Falcon Highlands Filing No. 3

Master Development Drainage Plan

March 18, 2022

SKP-21-004

JOB: 21000656  
SHEET NO. 1  
EX-01

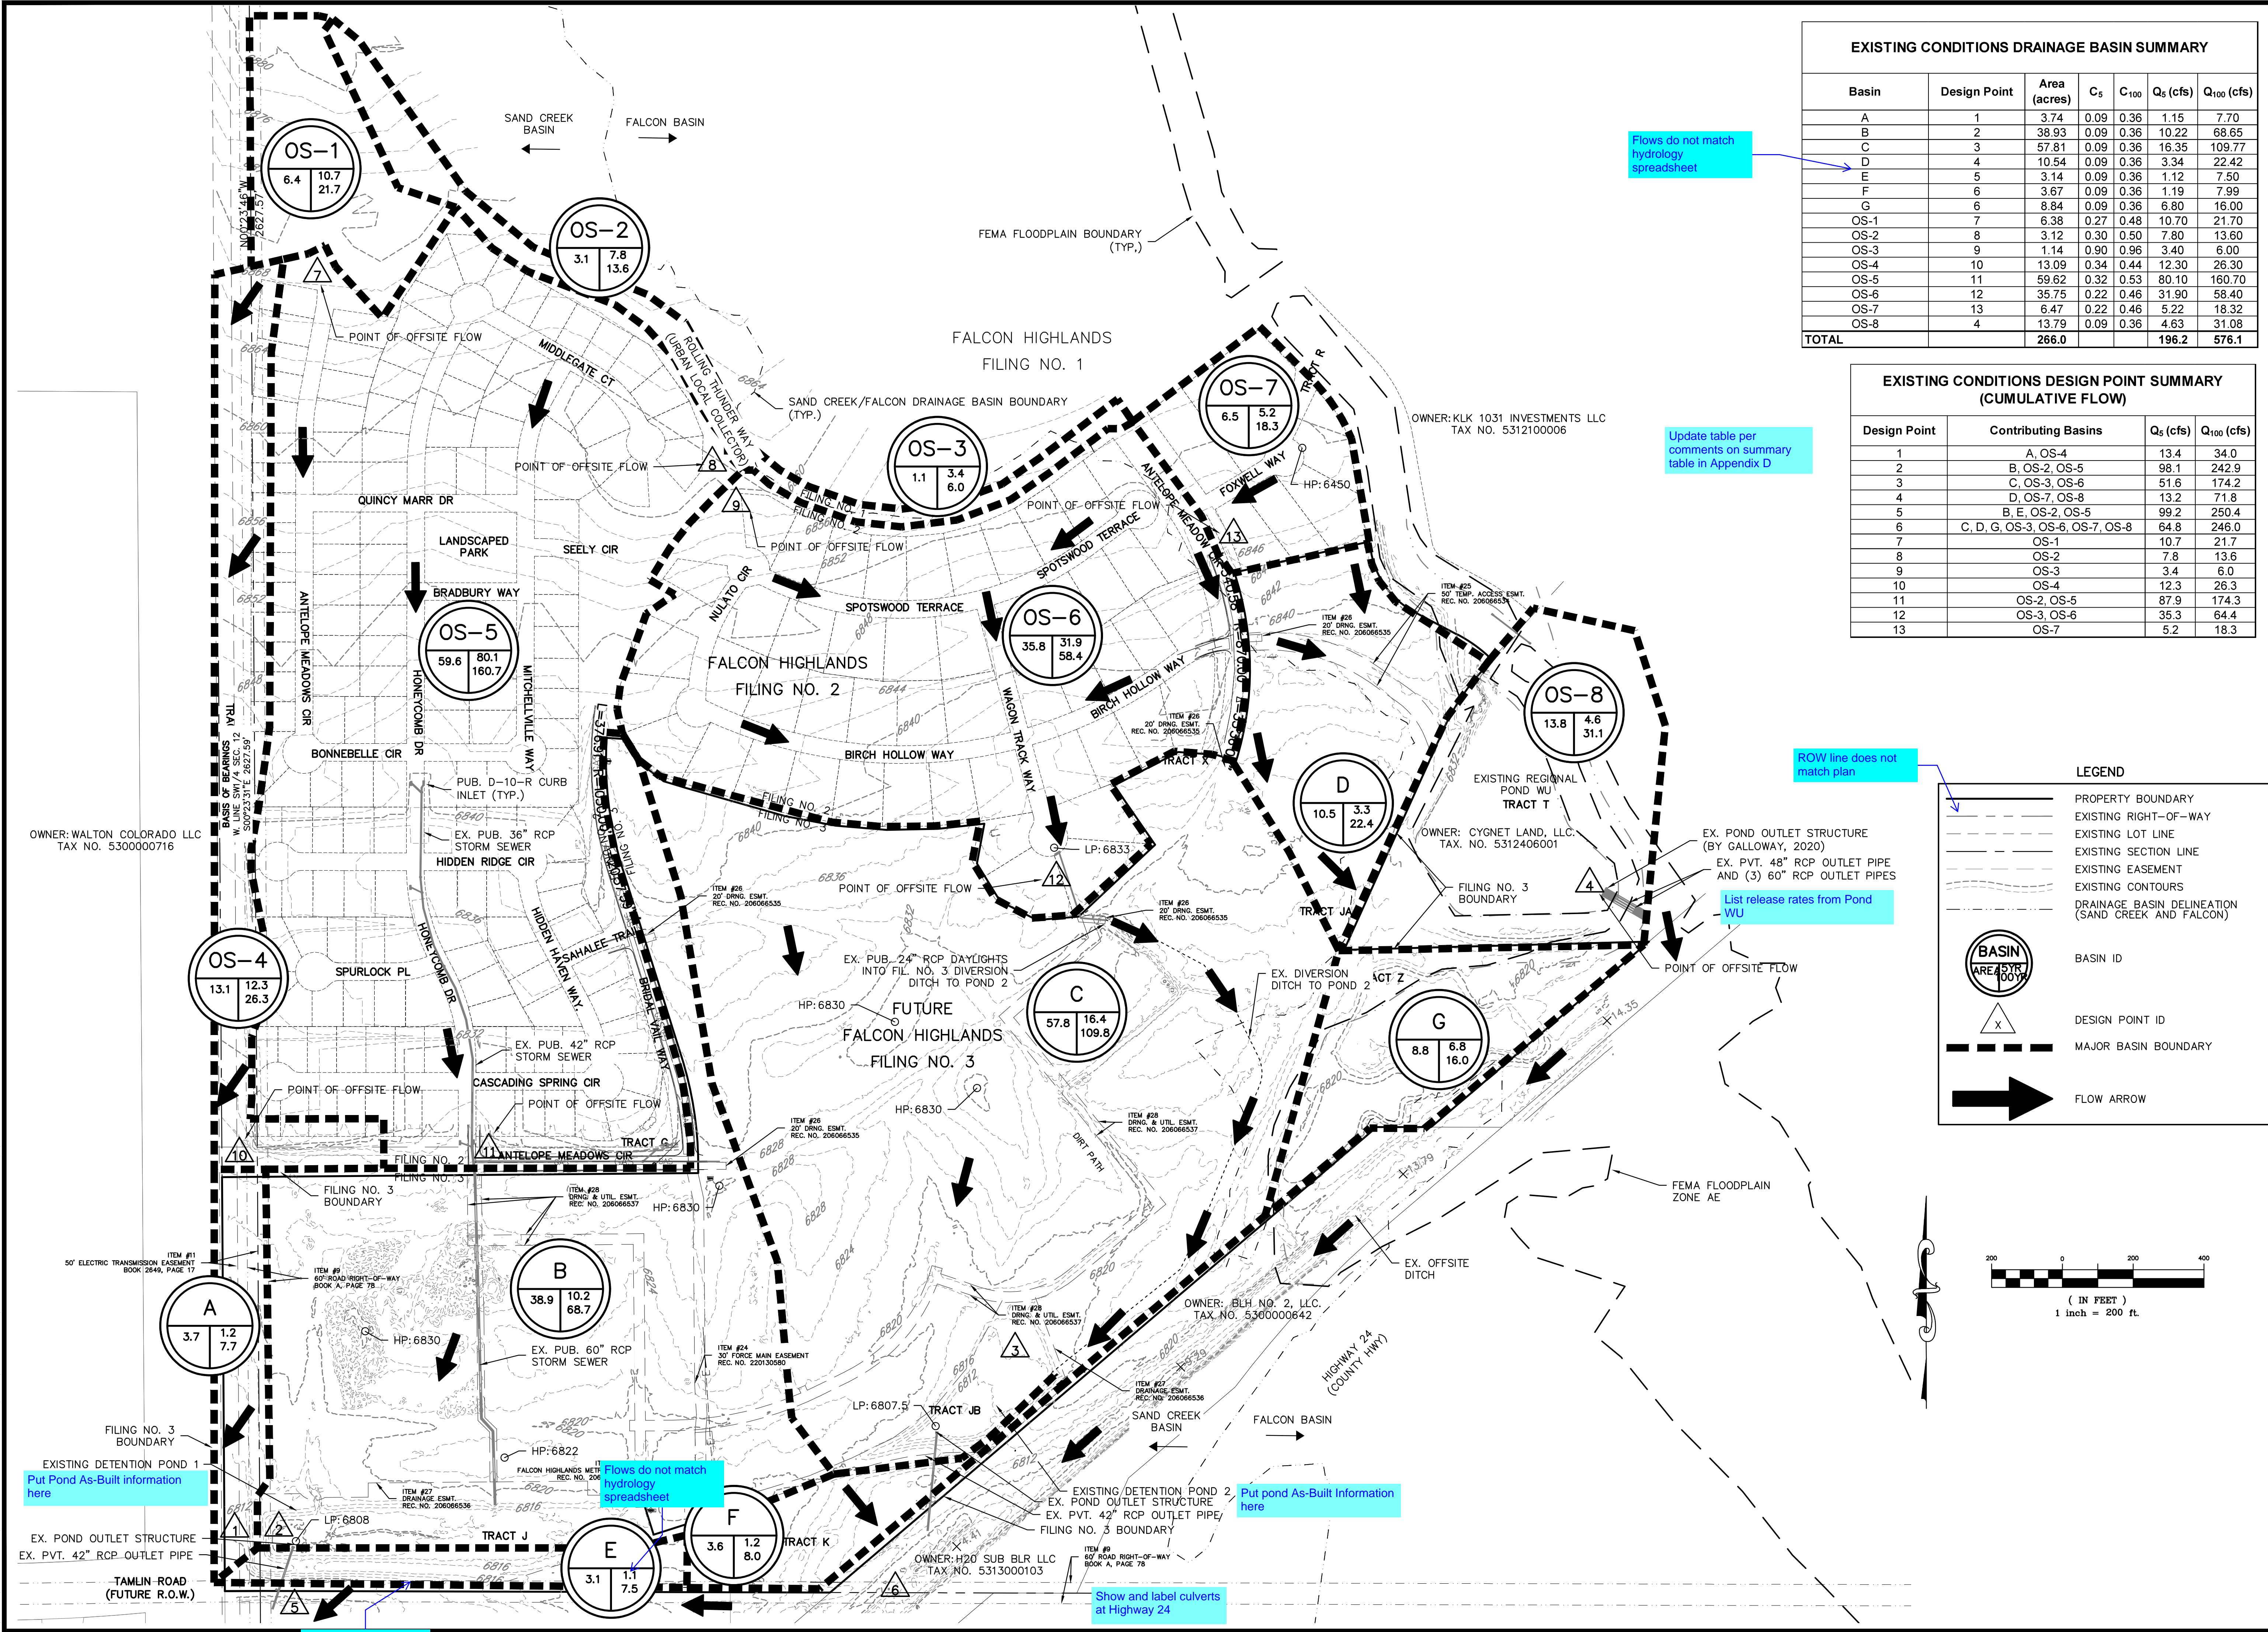
Flows do not match hydrology spreadsheet

Summary calcs were correct, updated hydrology sheets inserted.
